Your Ref: OWPC19680
Our Ref: WA/72/18/HH 11-07-2018
Please ask for:
Zac Denton

Single storey extension & detached annexe
Falling Foss West Walberton Lane Walberton

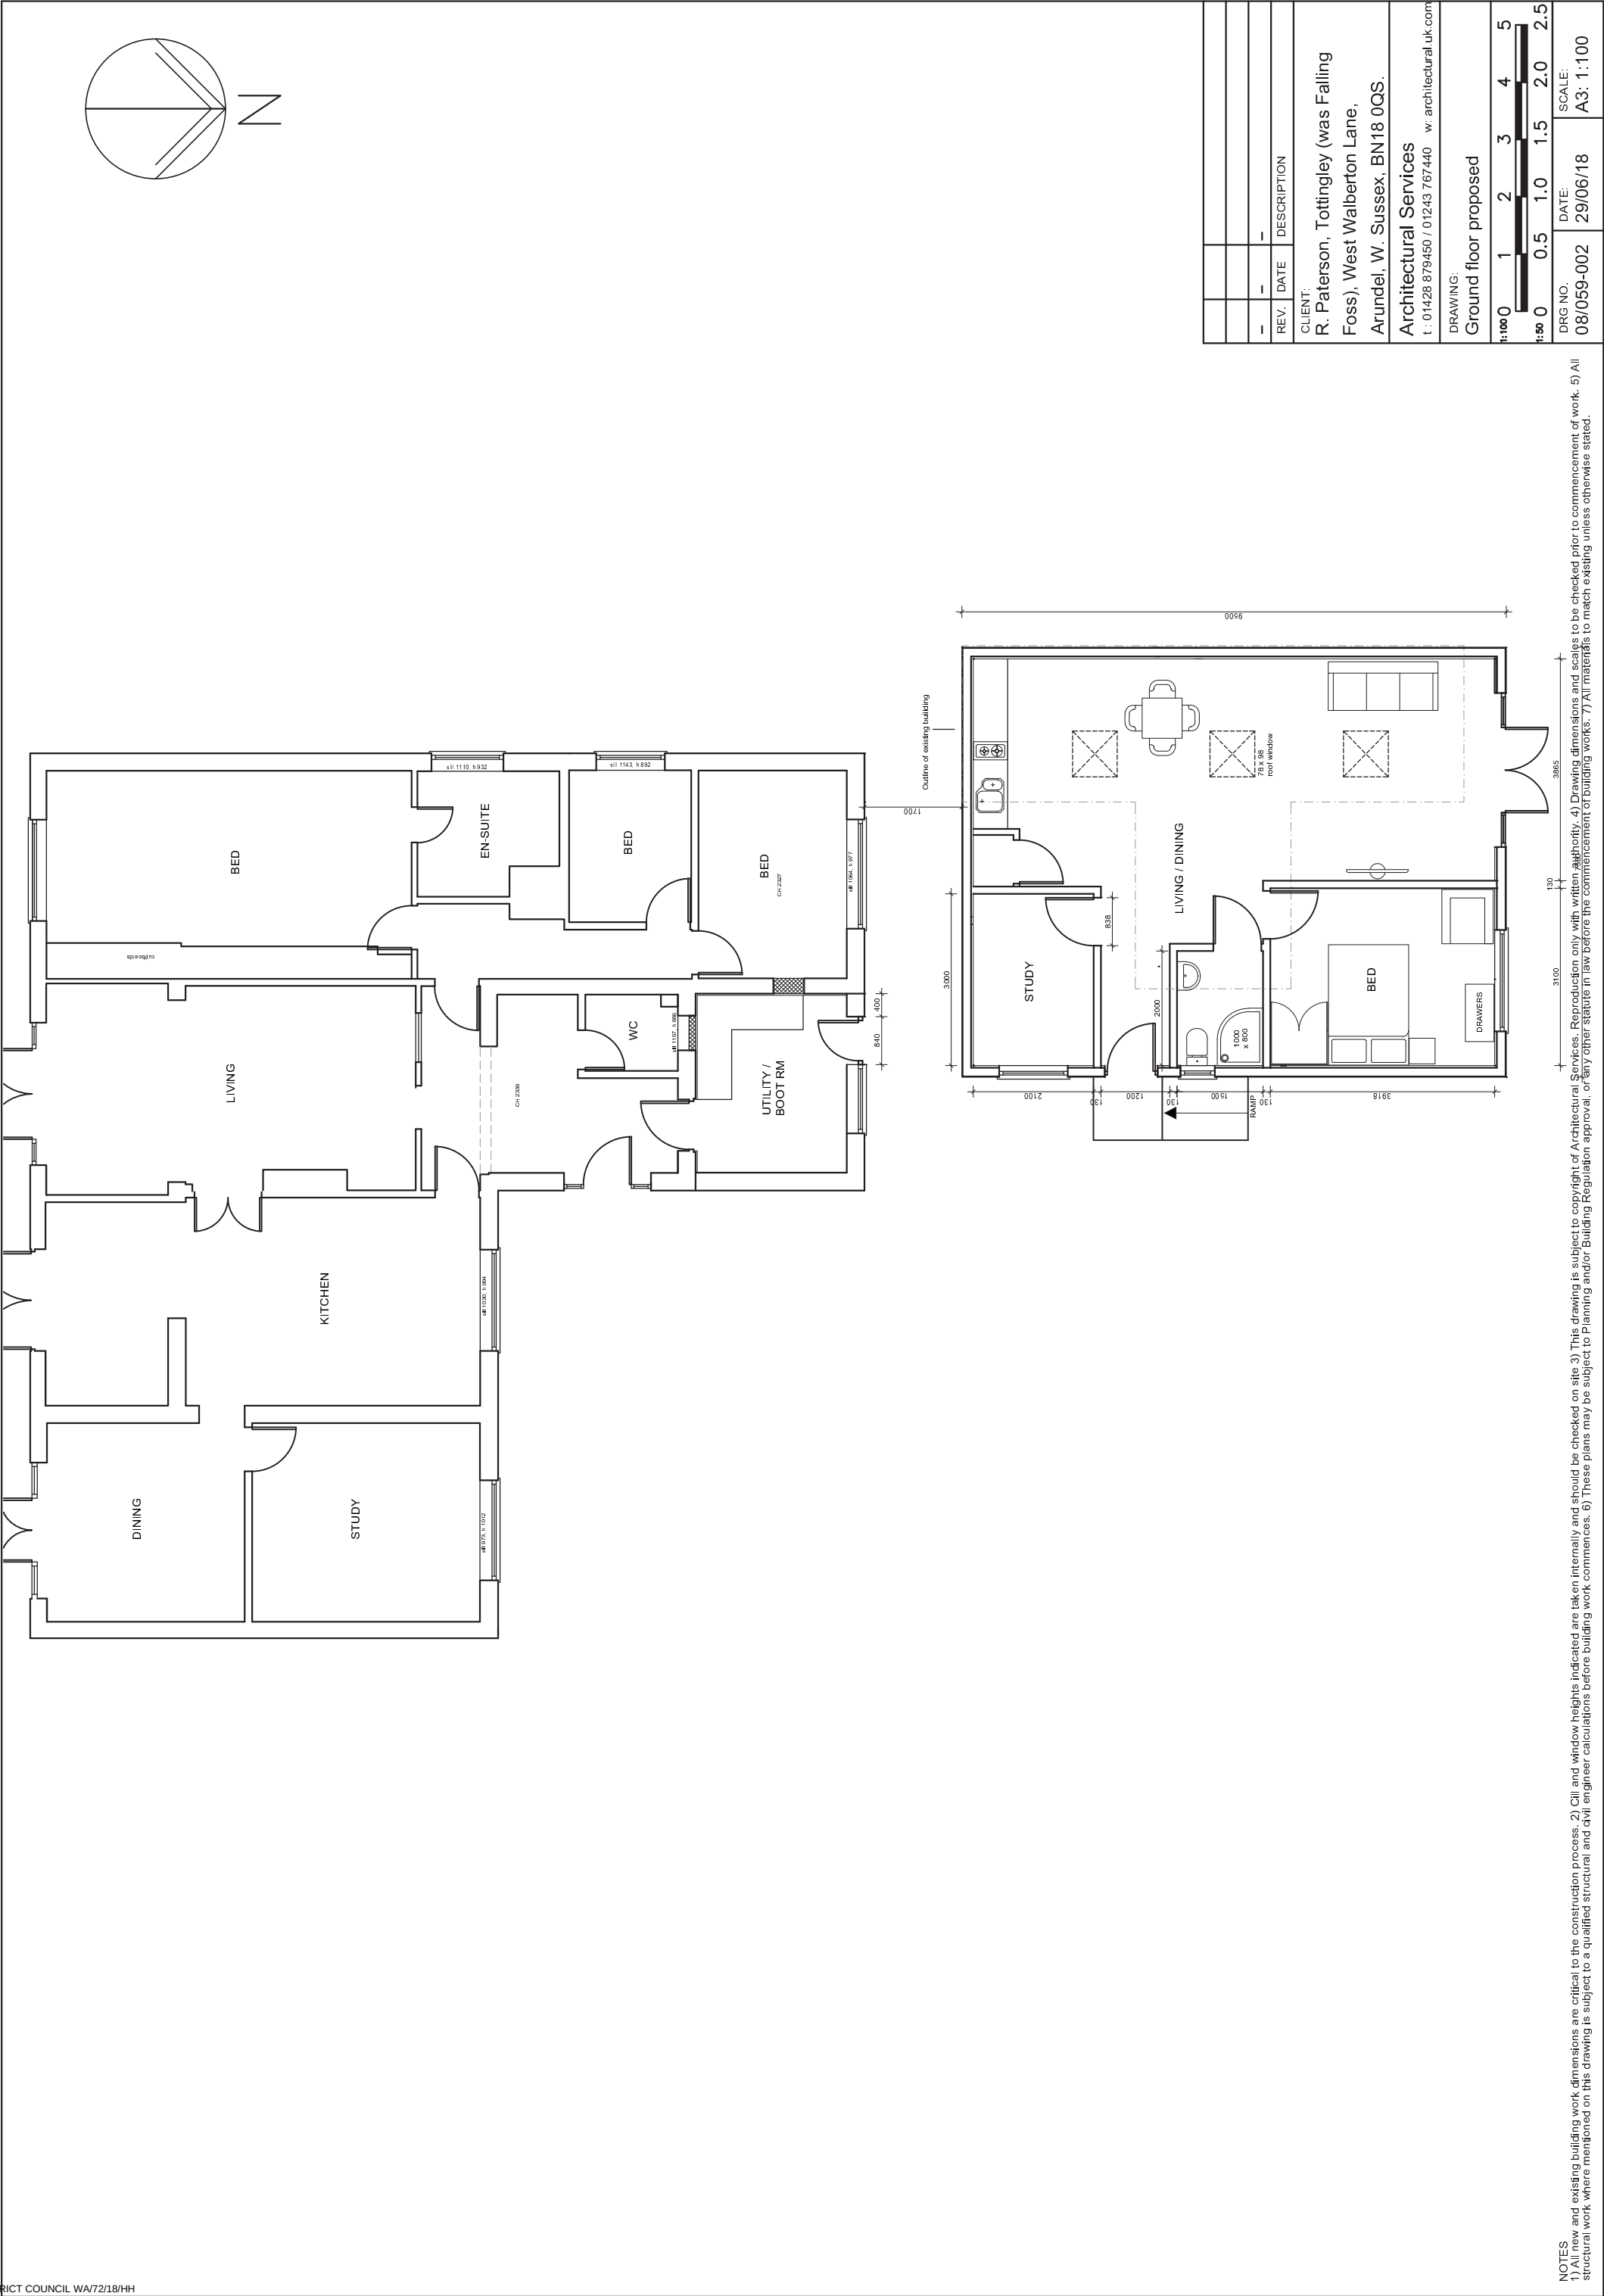
No objection with placing of a single storey annex in the front garden on the footprint of the current wooden structure but question the position of the boundary line between our properties as shown on the plans. There is a gap between our property and the boundary line as shown for example on the planning application for the 157 houses in the field behind our properties.
